WEST SUSSEX COUNTY COUNCIL CONSULTATION

TO:	Arun District Council FAO: Jessica Riches
FROM:	Stephen Gee WSCC – Highways Authority
DATE:	6 March 2025
LOCATION:	Land at Ford Airfield Ford
SUBJECT:	<p>F/14/24/RES</p> <p>Approval of reserved matters (layout, scale, appearance and landscaping) following outline consent F/4/20/OUT for the infrastructure RM including the provision of a primary spine road and associated secondary road junctions, pavement, footpaths, cycle infrastructure and bus stops; site wide drainage infrastructure including foul pumping stations, foul sewer infrastructure, SUDS basins, SUDS swales, surface water infrastructure; acoustic fencing; public open space including landscape details, play areas, footpaths & associated works. This application affects a Public Right of Way, may affect the setting of a Listed Building and falls within CIL Zone 1 (Ford strategic site - zero rated).</p> <p>More information received.</p>

DATE OF SITE VISIT:	n/a / XX/XX/XXXX
RECOMMENDATION:	More Information / Modification

Reserved Matters Infrastructure Primary Street (Central)			
Status:	For Planning	Drawn by:	GP
Project Number:	180641	Scale @ A1:	1:500
Drawing Number:	TOR-RMIN-XX-DR-L-P-006	Checked by:	TF
		Date:	06/2024
		Revision:	B

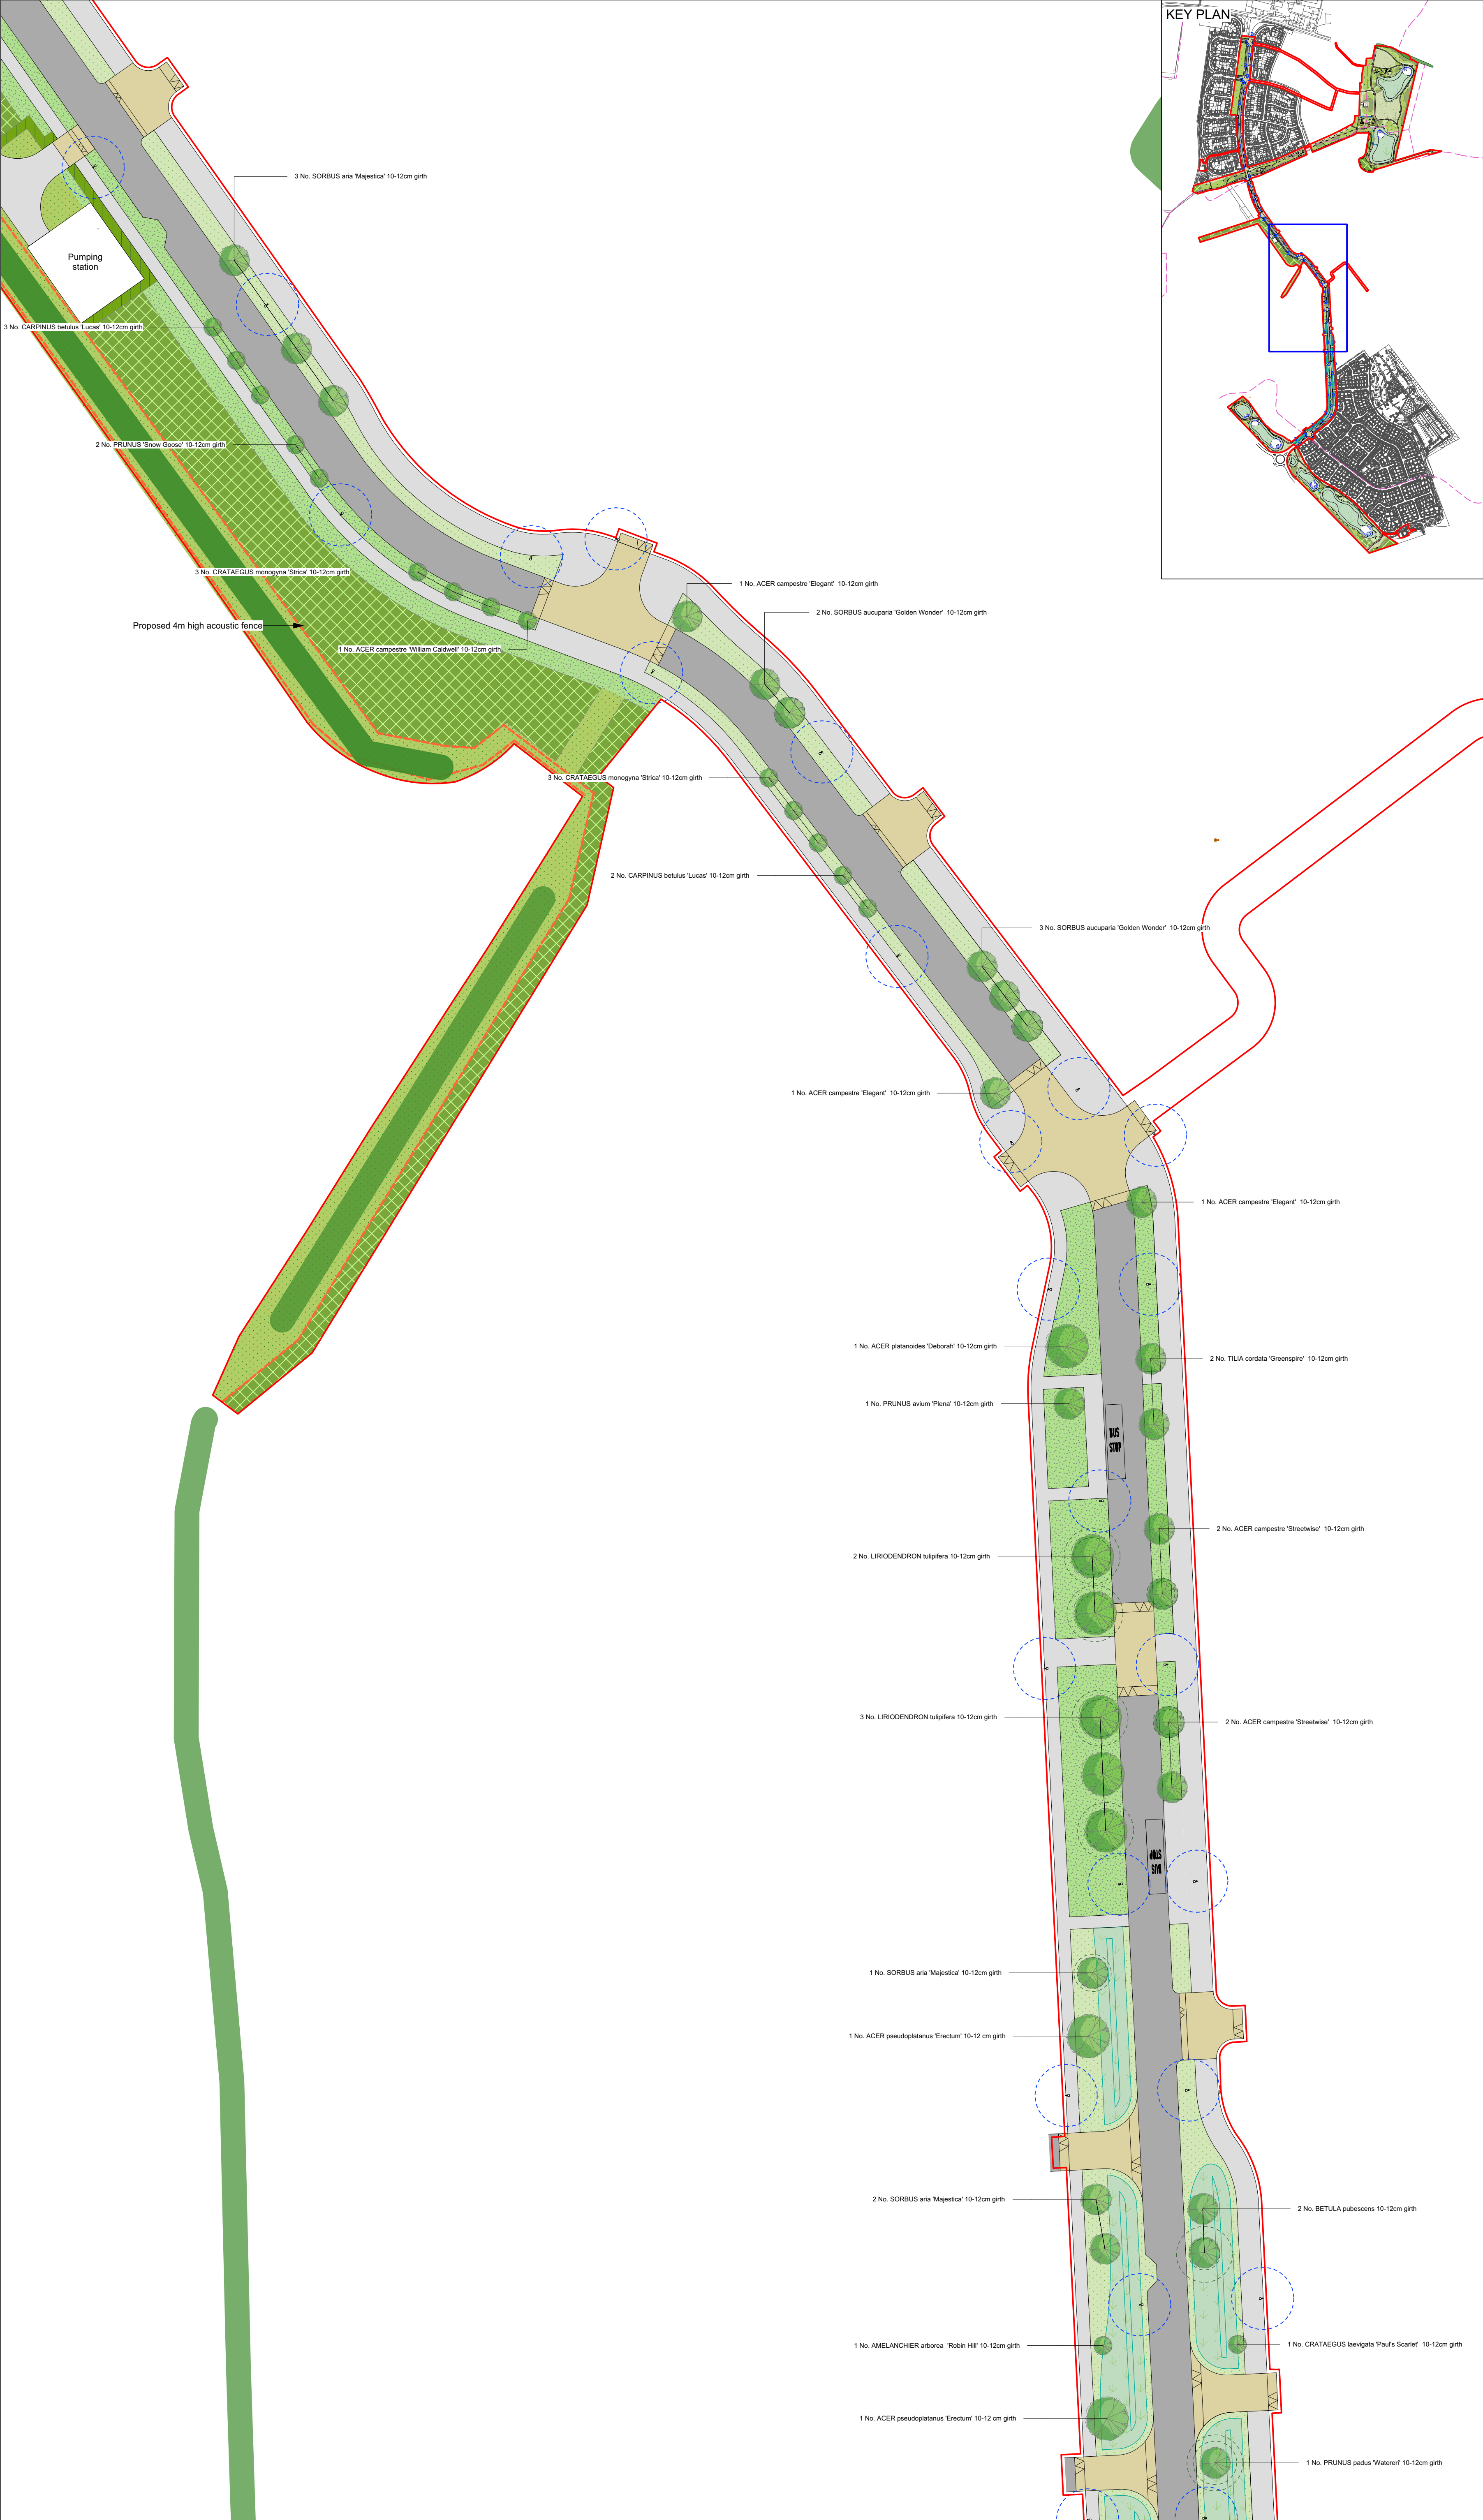
It is noted that the trees proposed in the Composite Landscape Masterplan do not match with those shown within the Transport Technical Note which details the visibility splays. Whilst slender girth trees would be acceptable within the splay, consideration of the cumulative effect should be provided.
